LAND USE PH COMMENTS

RE: BL-16-00015 NILES

NILES BLA 7-18-19

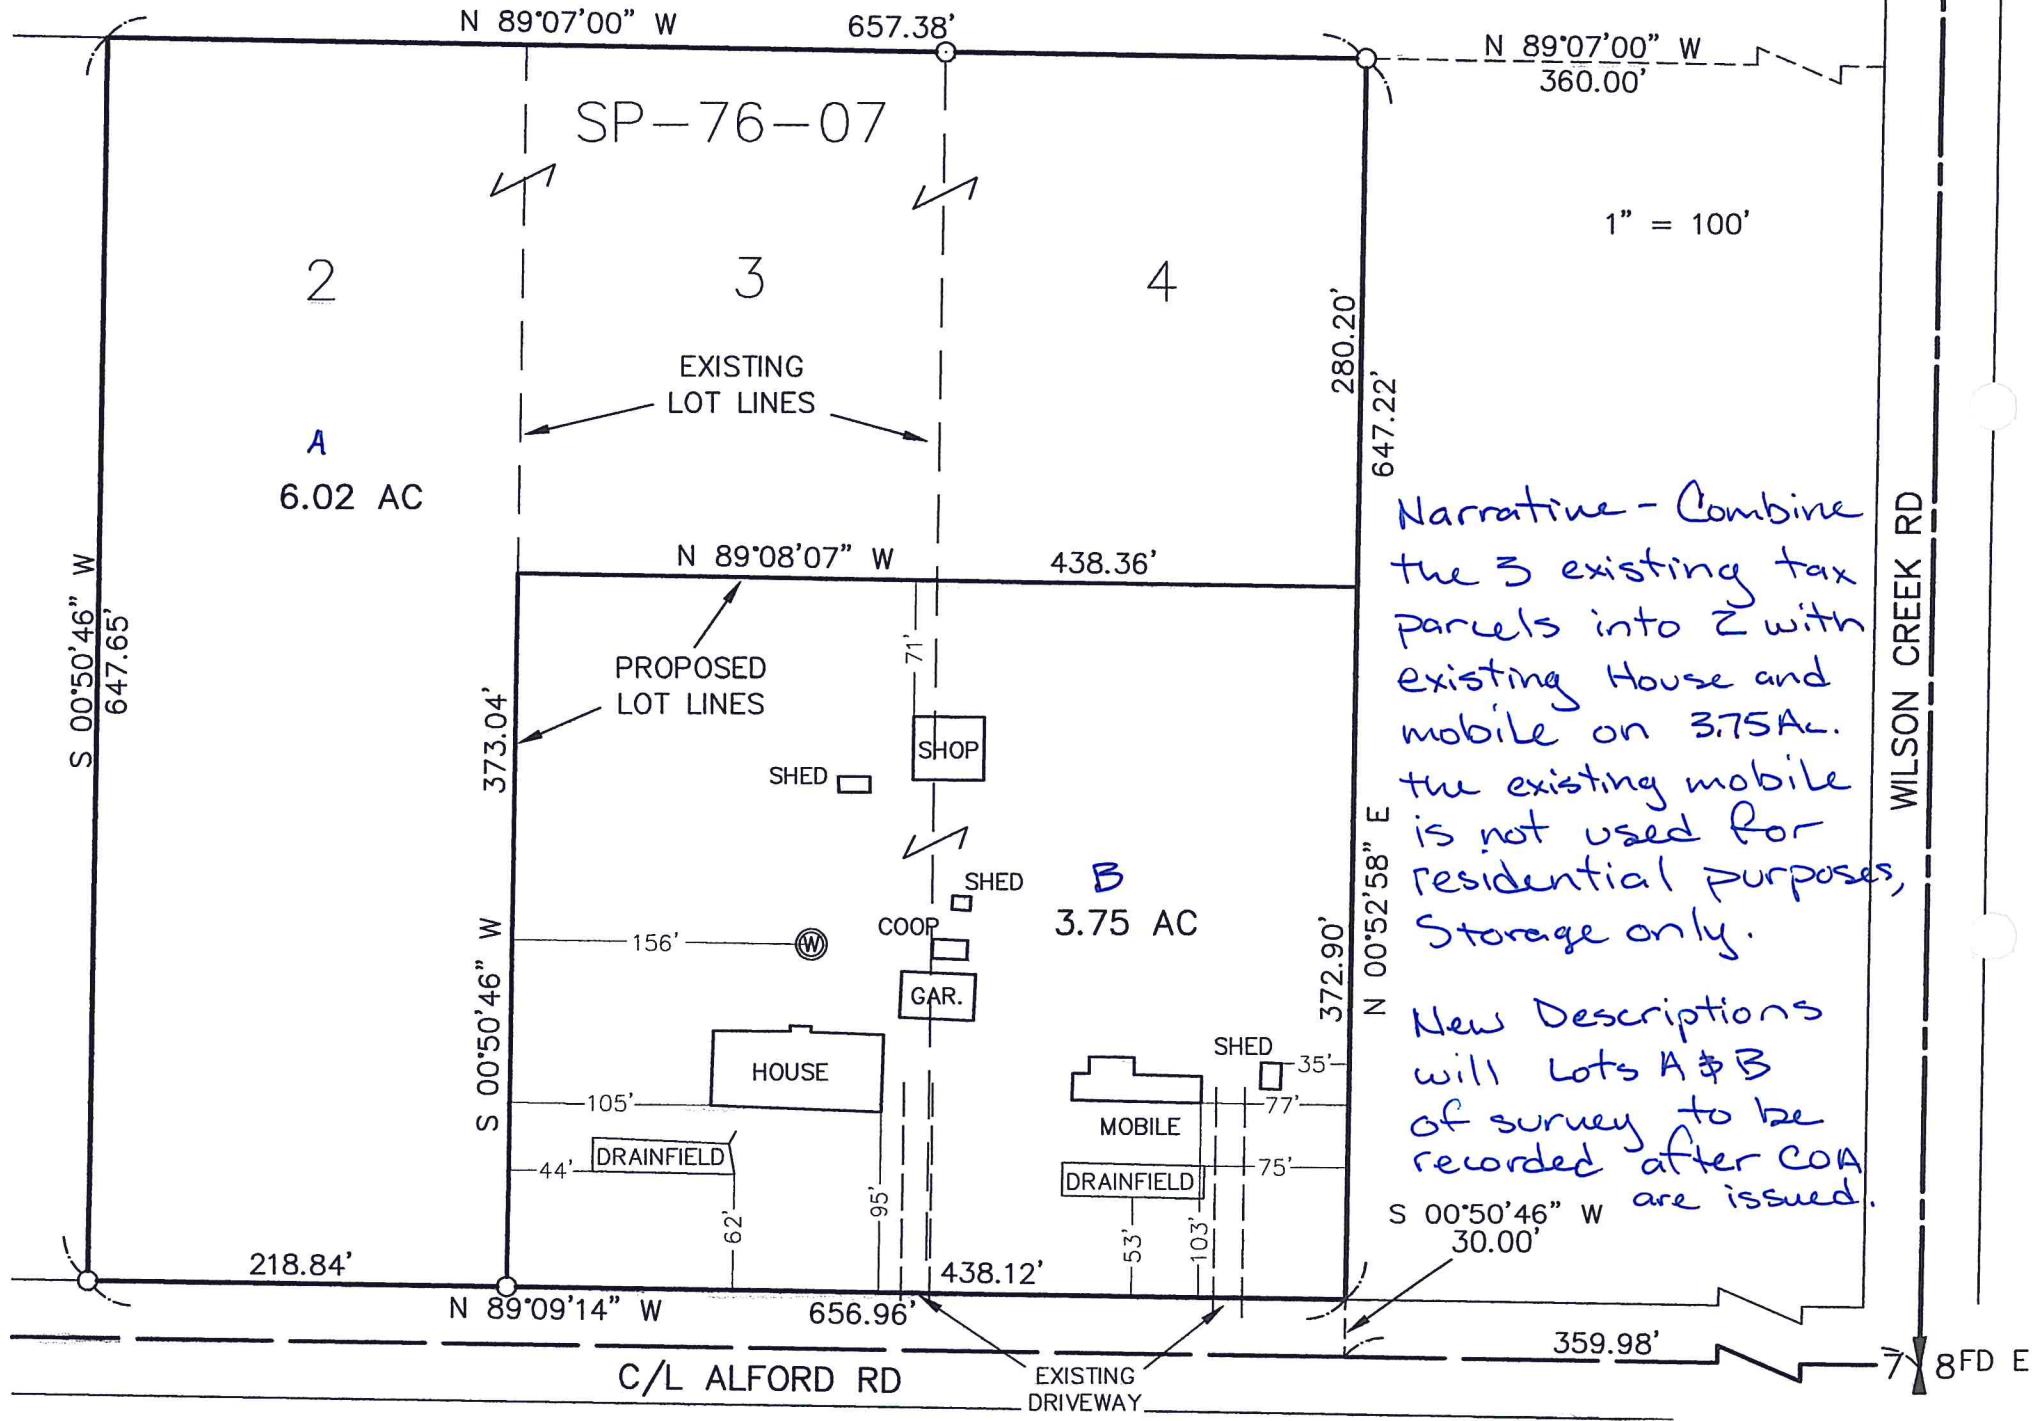
After review of this BLA, it appears the proposed changes will incorporate the existing homes, water source and septic systems within appropriate setbacks from the new proposed property line. Public Health has no additional water or sewer requirements.
